# CITY OF ALBUQUERQUE

**Re: Hanover Business Park, 6500 Hanover Rd NW,  
(J-10/D040A)  
Approval of Permanent Certificate of Occupancy—Approved,  
Engineer's Stamp Dated: 10-10-08  
Certification Stamp Date: 5-11-09**

**Re: Hanover Business Park, Request for Permanent Certificate of Occupancy (C.O.)  
Approved Engineer's Stamp dated 7/06/2007  
Submitted Engineers Stamp dated 10-10-08  
Certification dated 5/11/2009**

GRADING & DRAINAGE PLAN

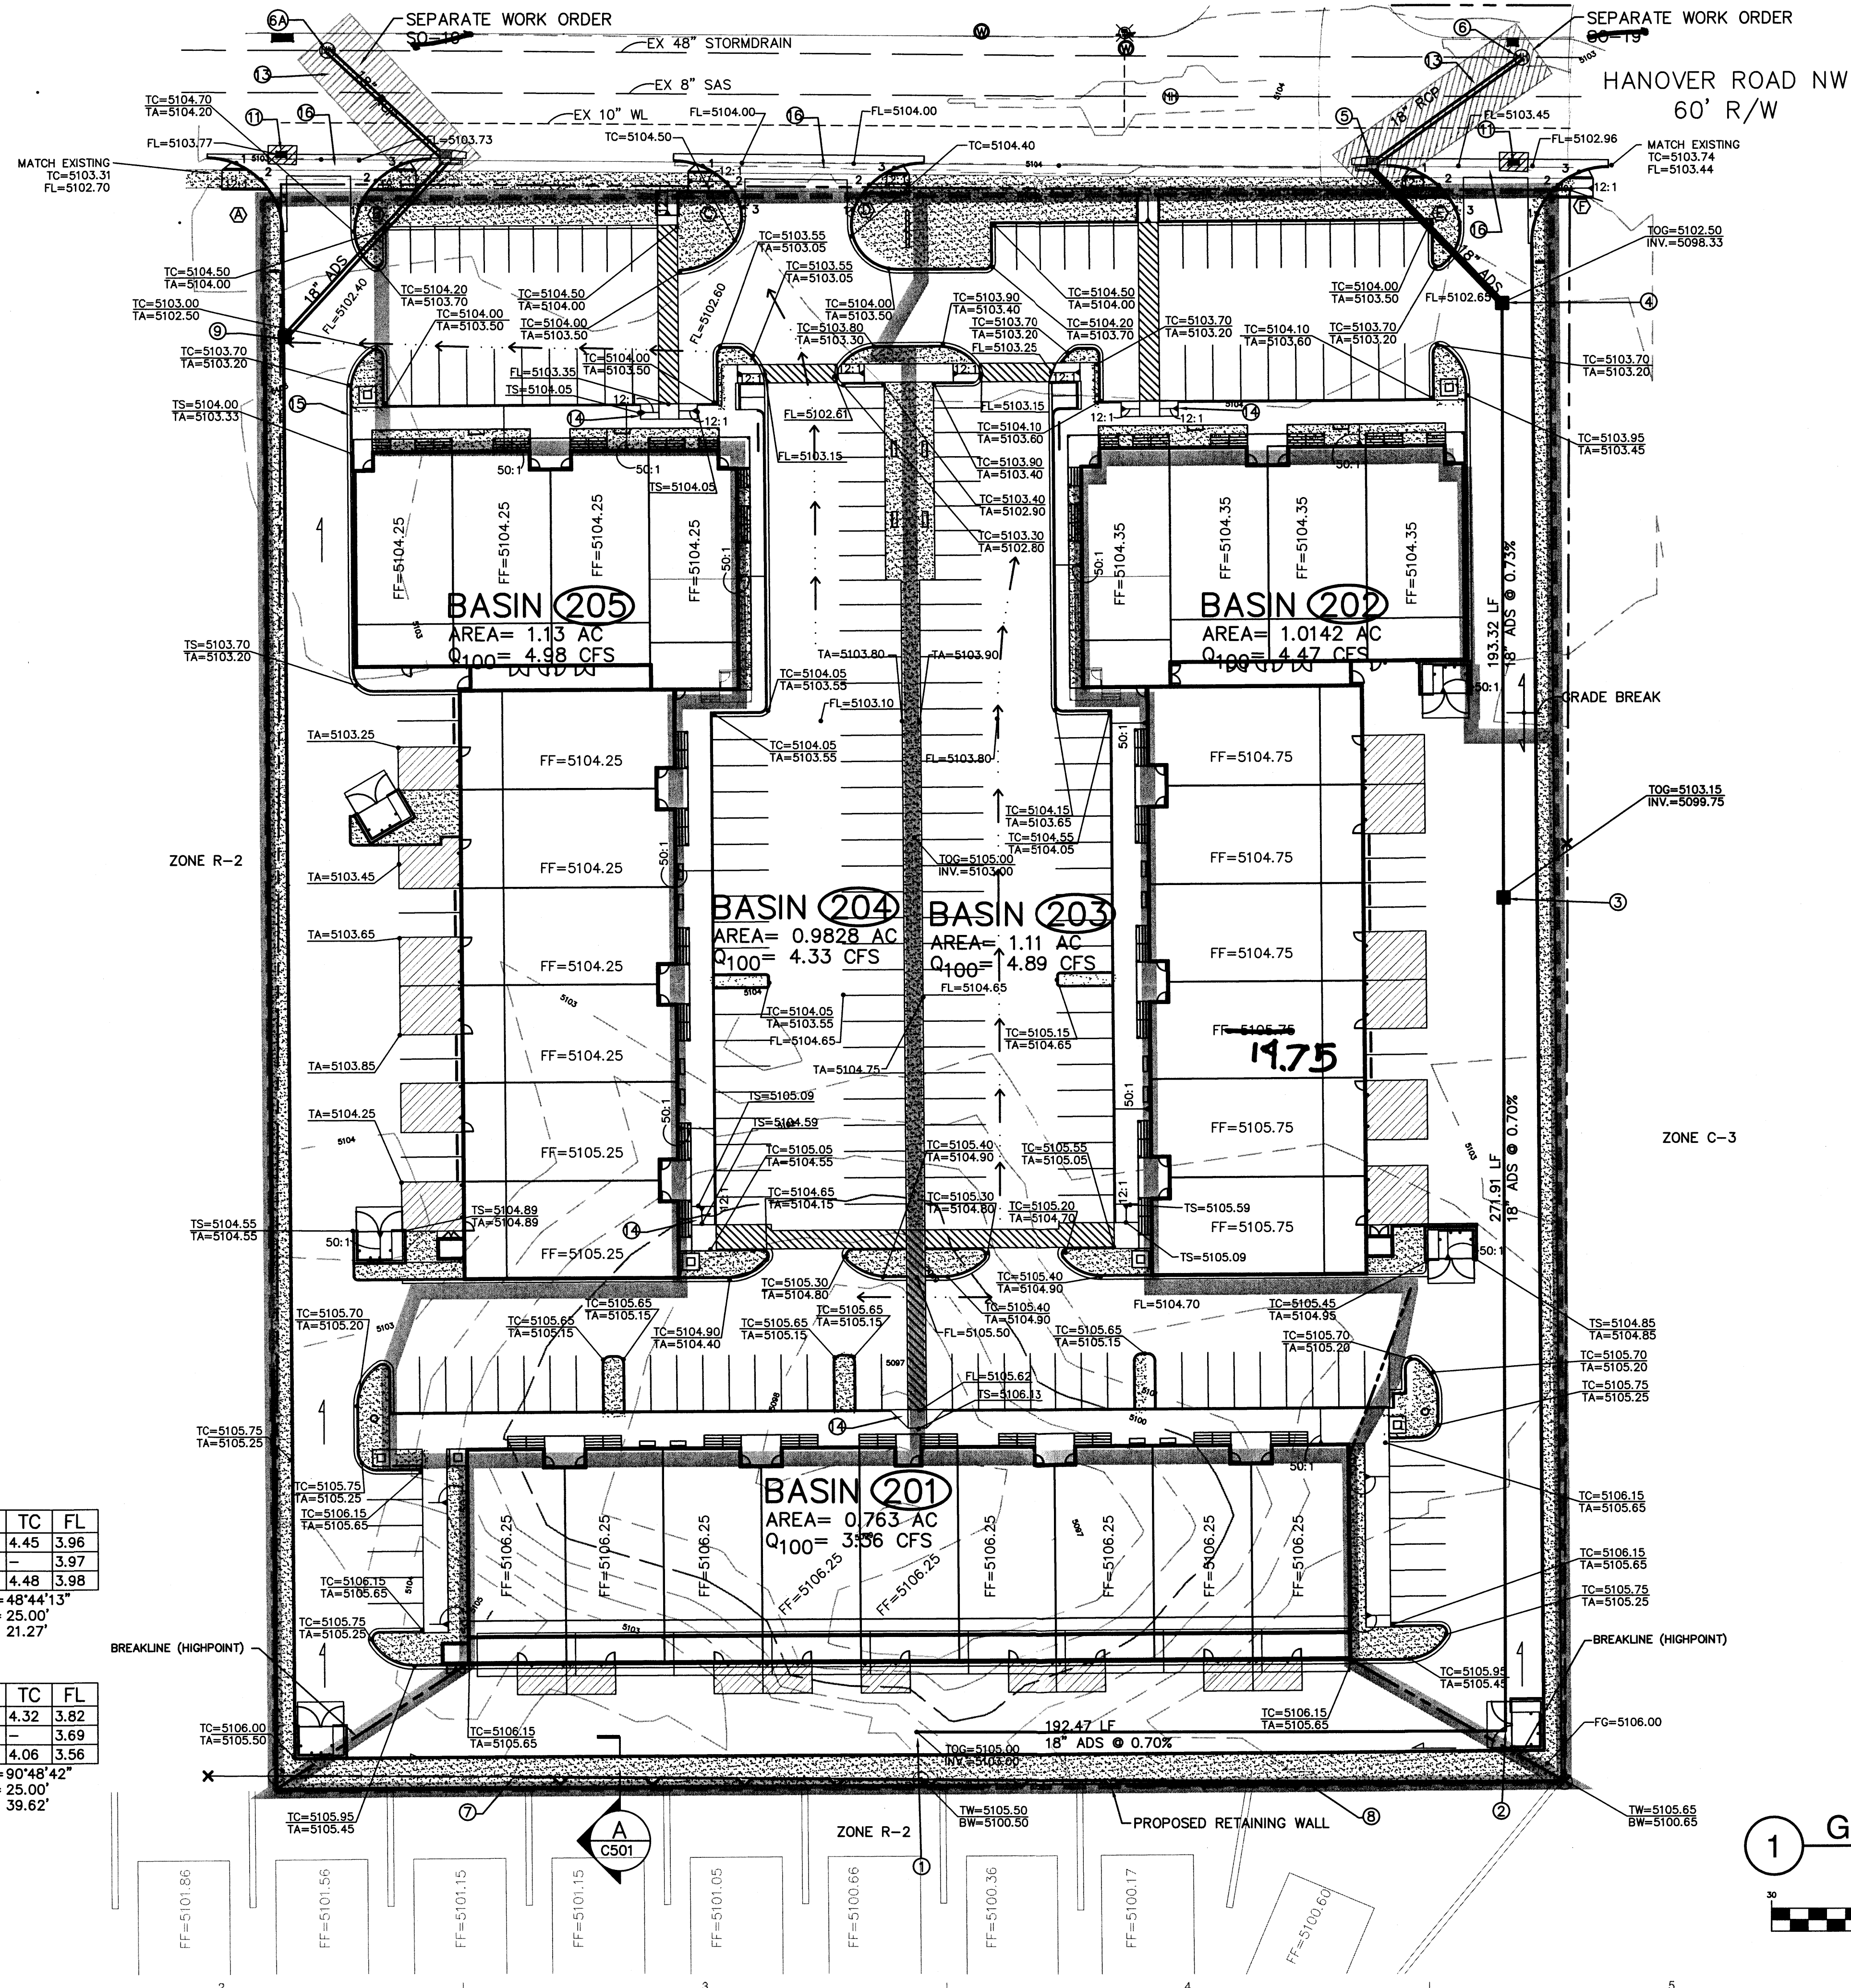
Item 3: Keyed Notes 9 & 5 will need as built elevations.

*Response: Noted; information has been added to As-built drawing.*
